**Objection to the proposed Valley Of The Winds Wind Farm project - State Significant Development Application - SSD-10461**

This is an objection to the proposed Valley Of The Winds (“VOTW”) Wind Farm project (“Project”) following review of the published Environmental Impact Statement (“EIS”). It is submitted that the proposed Project should be either refused or abandoned. Failing that, the Project should be refused in its current form, significantly revised and re-exhibited.

**Figure 10. Amendments to Girragulang Road (GR) Cluster**

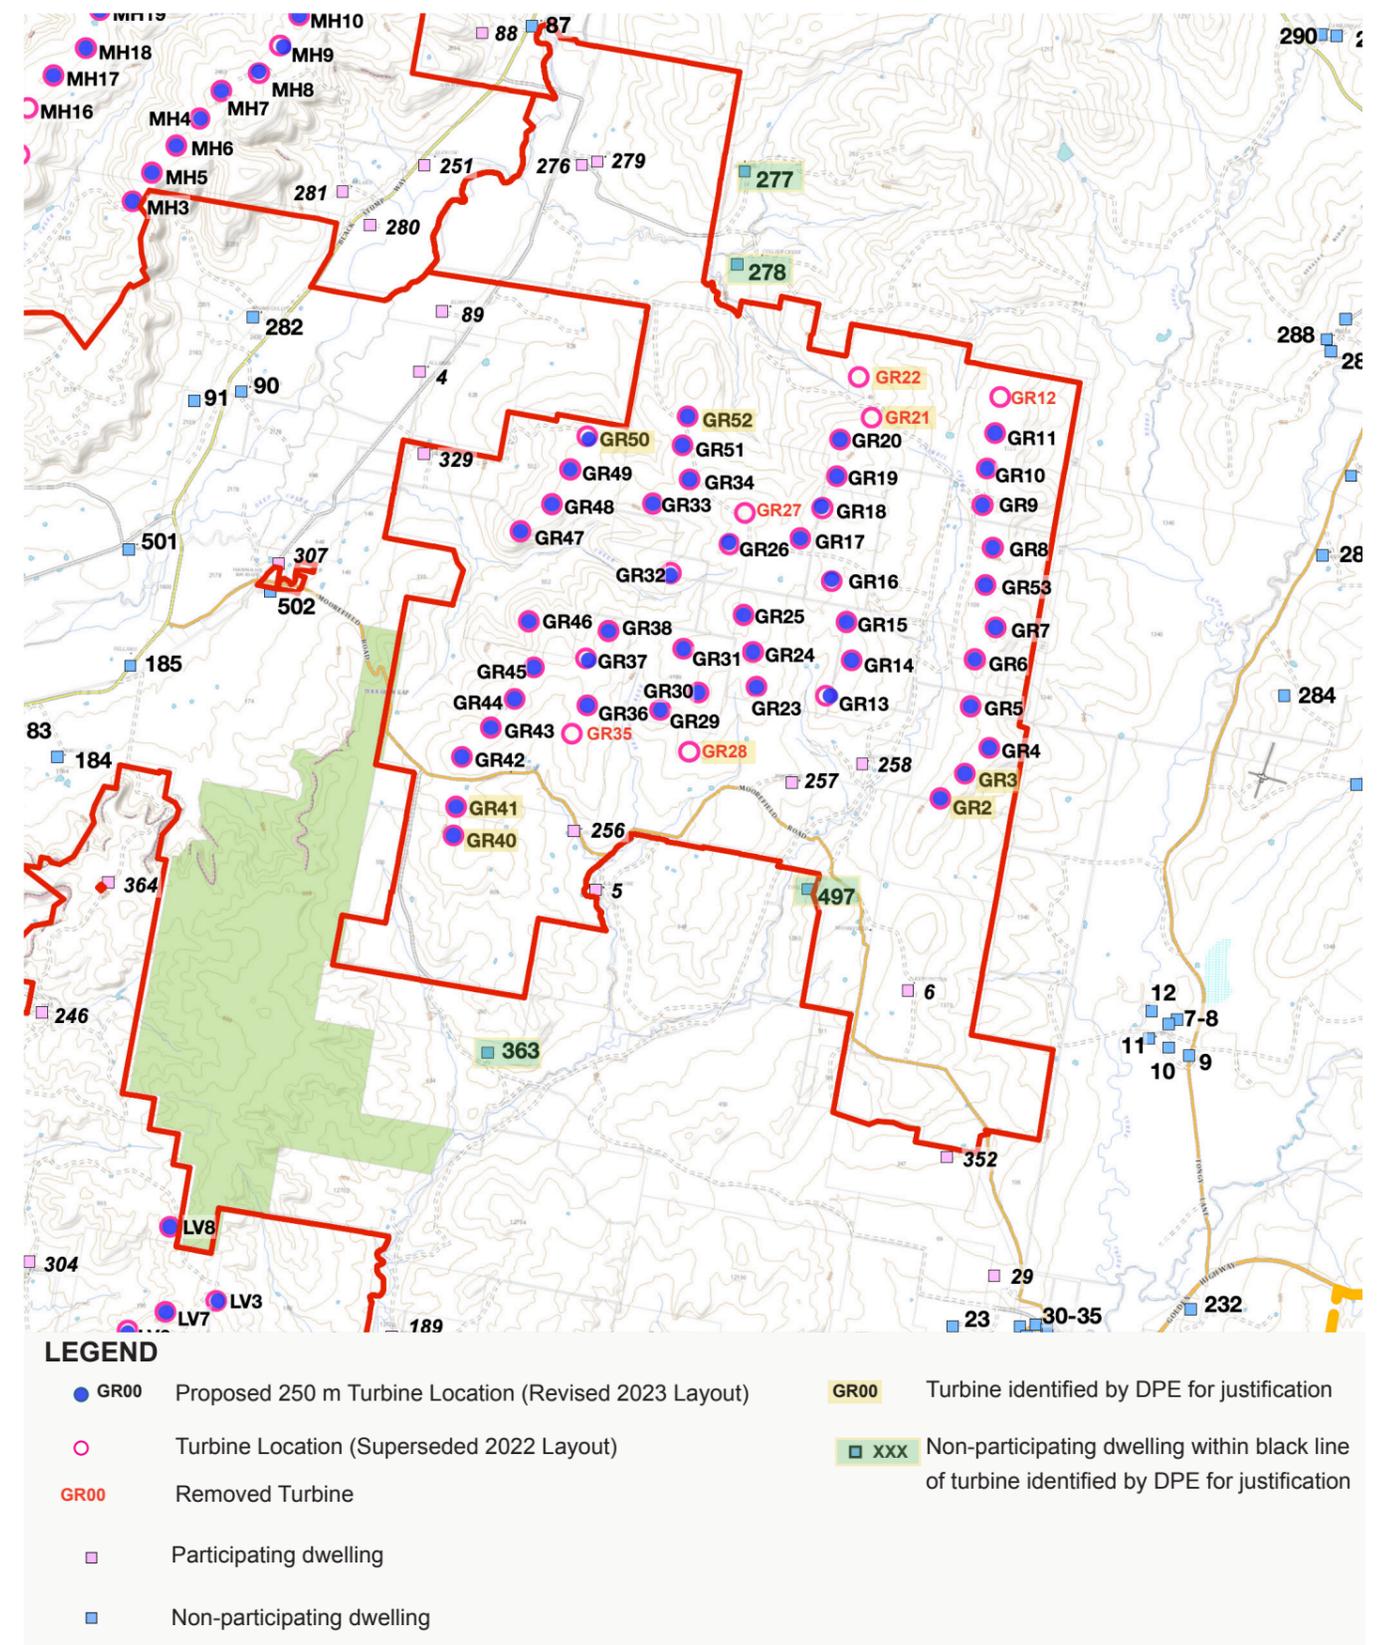
- The specific impacts of the Project on Tongy Station, which are severe due to the proposed location of the Girragulang cluster of turbines:
  - The visual impacts as assessed in the EIS on the areas of Tongy Station and dwellings (7 – 12 inclusive and 283) are ill-considered, as further referenced below. The Girragulang cluster of turbines will dominate Tongy’s western skyline due to their physical elevation on the ridge line. As proposed the turbines will actually tower >350m above the Tongy landform and the occupied dwellings, thereby destroying the scenic value and ambience of the property. This is unacceptable. The rural landscape within and surrounding our property is vitally important to those that live and work within it and no assessment has been conducted in the EIS to assess the scenic value of our landscape, primarily because the NSW planning system is lacking in that it does not place any requirement to consider impacts to scenic value. Rather, the planning process calls for subjective assessments of visual impact, carried out by consultants using a reference system defined in the NSW Wind Energy: Visual Assessment Bulletin (DPE, 2016), which is outdated given the material increase of turbine height from 190 meters to the 250 meters turbines proposed. As such I believe the EIS assessment of scenic impact is flawed, as it does not consider scenic value of surrounding properties to the Project. The high scenic value of our properties is at risk of being materially diminished by the Project.

- The EIS states the turbines will impact operations of the Tongy airstrip, both by proximity of the turbines to the circuit operations of the airstrip in addition to creating wake turbulence across the airstrip. The Tongy airstrip is a critical component to farming operations, particularly for use in applications by air. The airstrip has been in place for nearly 100 years and is the designated alternative airstrip to Coolah. The airstrip cannot be re-located on Tongy due to local topography. As depicted in the EIS, the proposed Girragulang cluster turbines will cause the airstrip to be unsafe and therefore will materially and negatively impact agricultural operations of Tongy Station in addition to preventing use by my neighbor who depends upon it, as well as use by other operators and availability for emergency services (such as Royal Flying Doctor Service). The technical assessment relating to airstrip impacts is flawed and further consultation and assessment is required. These gaps raise serious safety issues. The only remedy is removal of the offending Girragulang cluster turbines.

- The existence of the Girragulang cluster of turbines will prevent aerial fire fighting by fixed wing aircraft for the Tongy locality. Fire fighting air services were a critical part of the attempts to contain the Sir Ivan fire in 2017. As an example, in this case the NSW Rural Fire Services prevented ground units entering the Turee Creek valley locality during the fire, such that only aerial fire fighting could continue. Helicopters are useful in spotting fires and protecting buildings assuming they have unfettered access to dams for replenishment. But only fixed wing aircraft can contain large fire fronts and they need to operate from the nearest suitable airstrip. The task is difficult enough due to smoke and wind - adding the proximity of transmission lines to the operating risk cannot be allowed. Consequently, it is submitted that by interfering with safe aviation operations the Girragulang cluster of turbines will increase the risk of bushfire in the Tongy locality, which is unacceptable.

Figure 22. Cumulative Visual impact Assessment

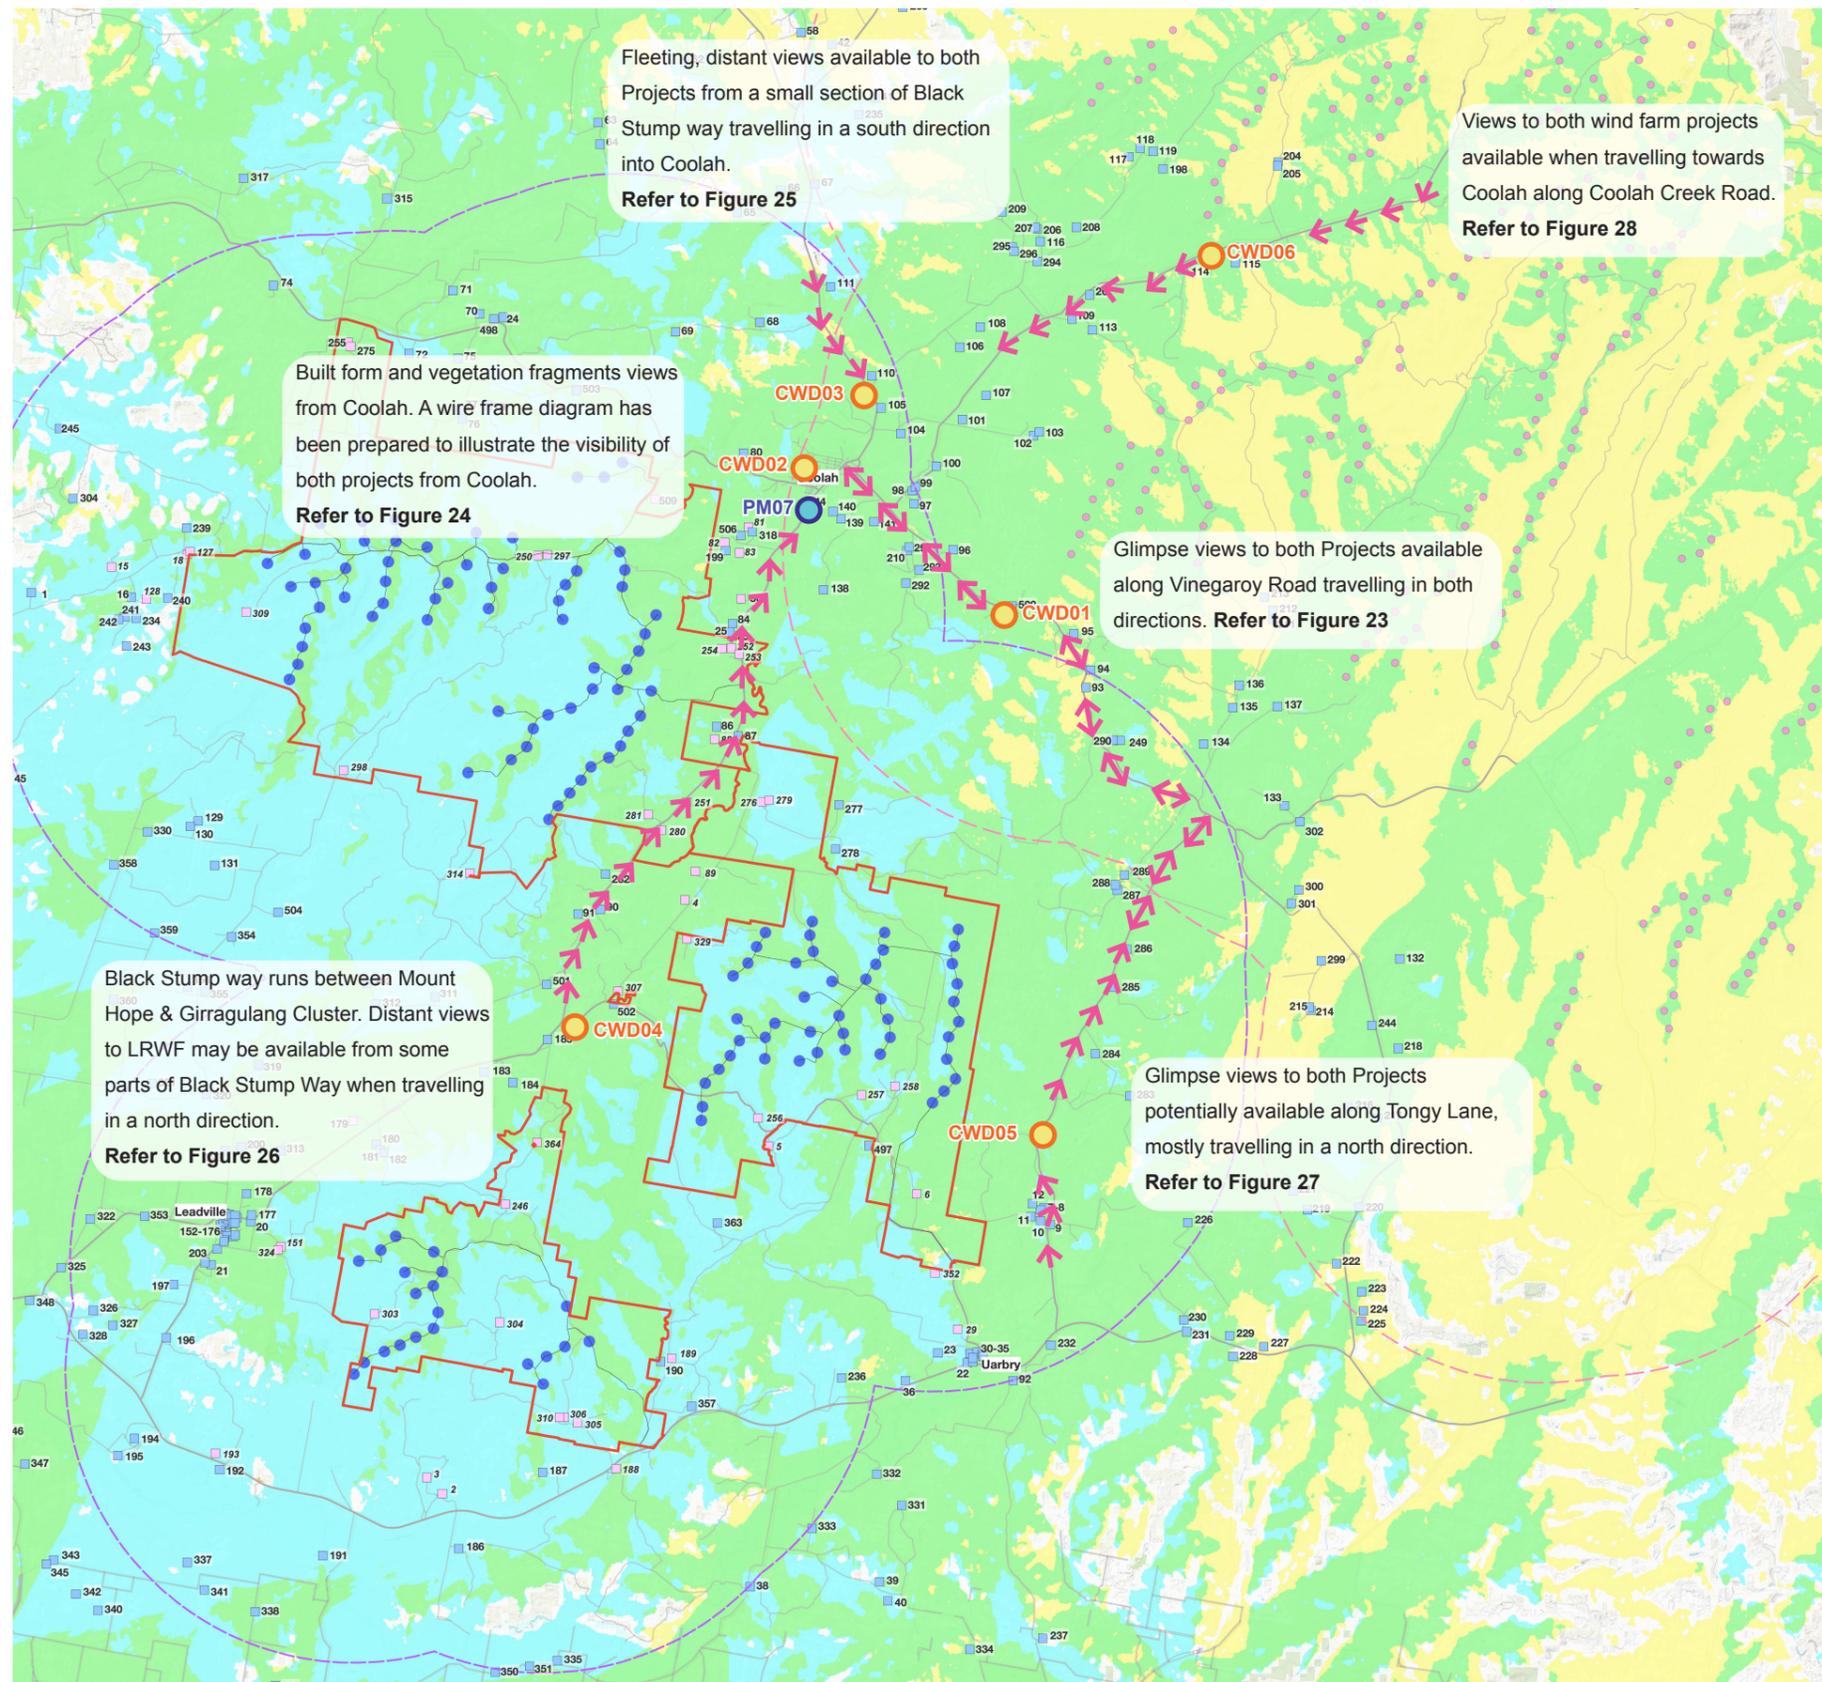
- The cumulative visual impacts on the Coolah district from the combination of the VOTW Wind Farm and the Liverpool Range Wind Farm, and the major new powerline assets, are so severe that the Project should be abandoned. Each of the 371 proposed turbines which will completely surround Coolah are nearly as high as the Barangaroo building which towers over Sydney's CBD; almost double the height of Sydney Harbour Bridge. This is way too much concentration of the world's largest on-shore turbines for the Coolah district and is a further example of the poorly conceived implementation plan for the Central-West Orana REZ.

Figure 27. CWD05: Cumulative Wire Frame Diagram - Tongy Lane

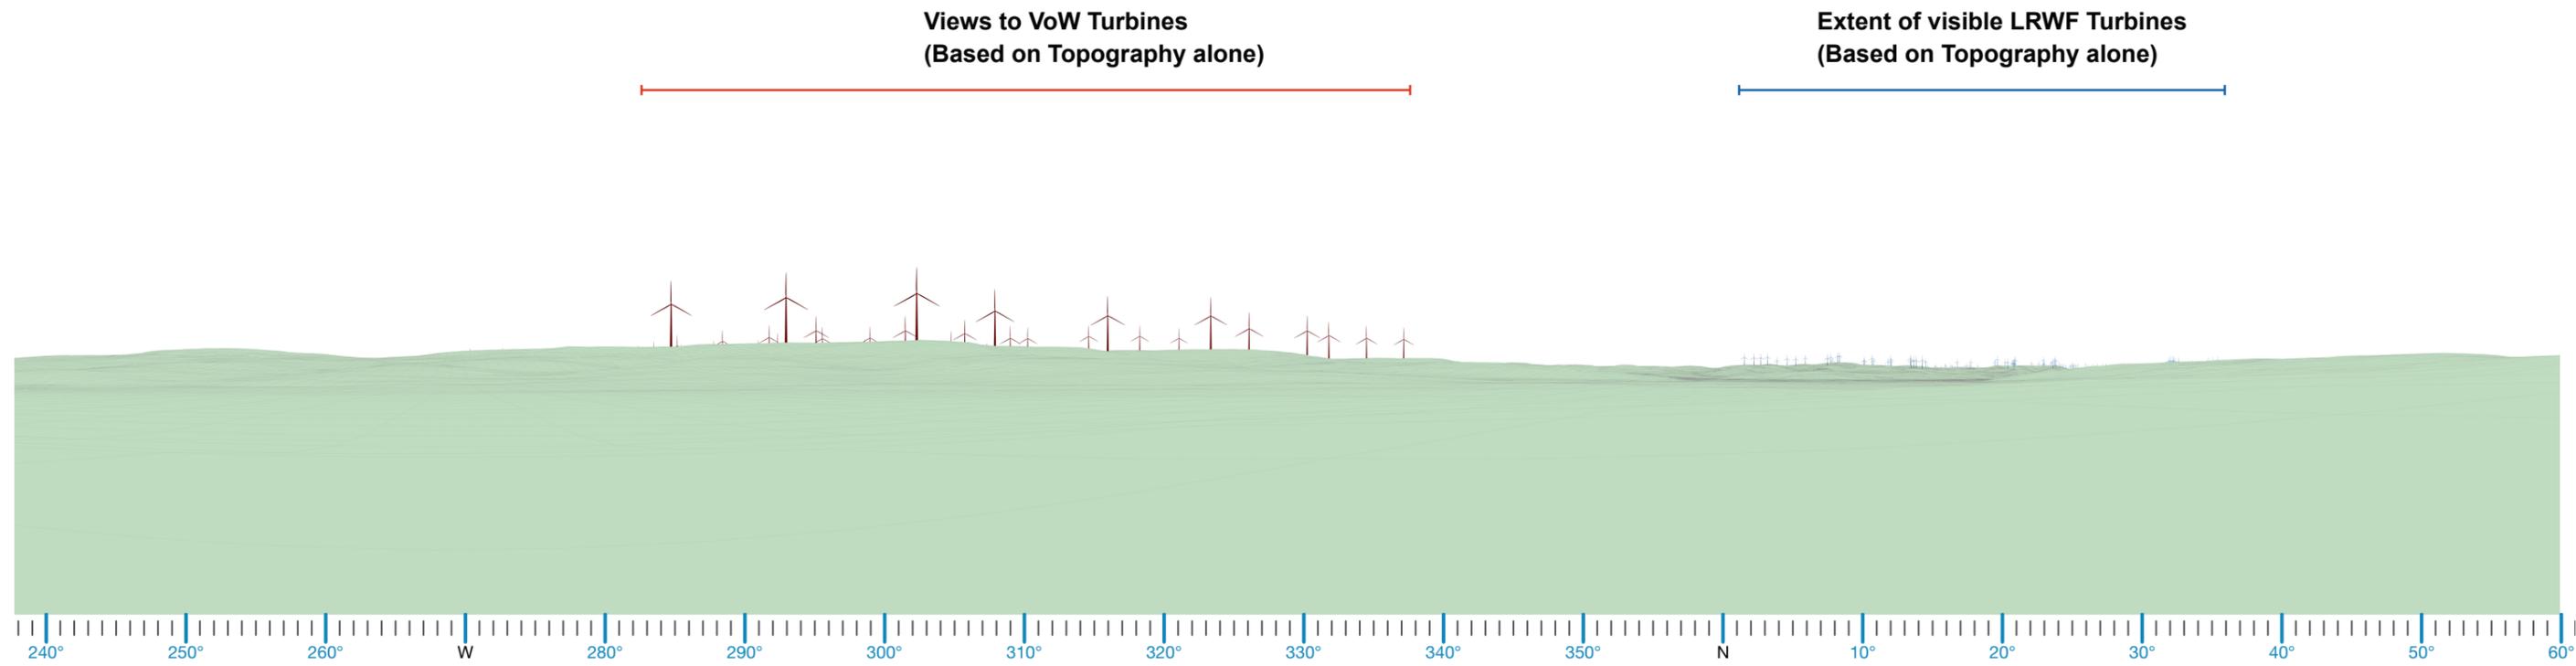
- Meaningful photo montages or best available 3D imagery should be completed by an independent expert (and not conducted by the Project) for all non-associated properties as well for public viewing vantage points, such as the Coolah look-out on the Cassilis/Vinegaroy Road and along Tongy Lane. There are nil 250 metre high turbines in Australia, and a total lack of familiarity by the community as to their scale. Montages and/or 3D imagery should also include any contemplated transmission lines in the area whether by NSW Government or the AEMO.
